Application No: EP/124/20/HH
Site Address: Little Dormers 23 Upper Drive East Preston BN16 1QN
Description of works: New bay and porch skirt roof to the front elevation, and roof linked detached double garage.

Thank you for your internet representation made on 18th November 2020 which has been recorded as an objection with the comments as follows:

Location Plan and Block Plan

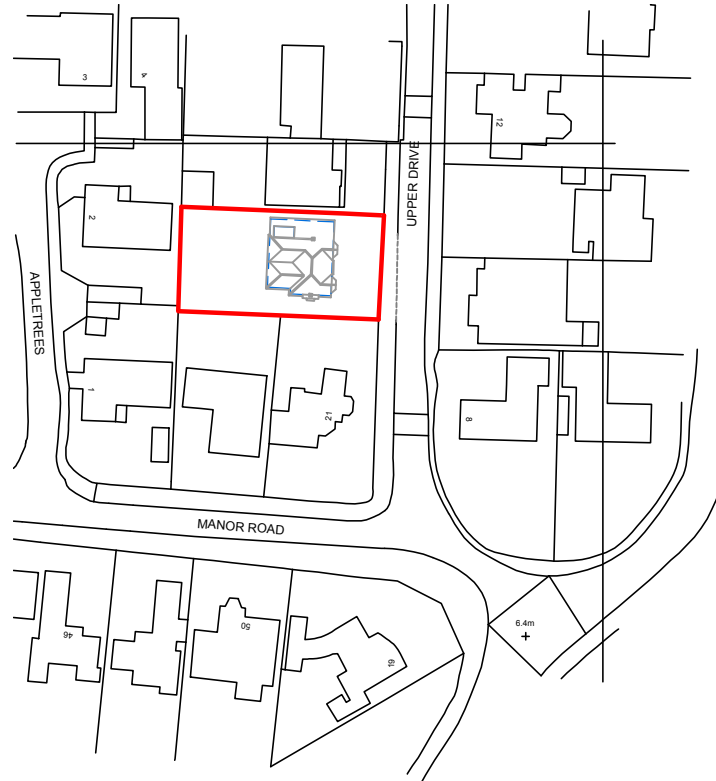
The proposed structure will spoil the look of the road and the estate.
The proposed garage is large and comes almost to the road.
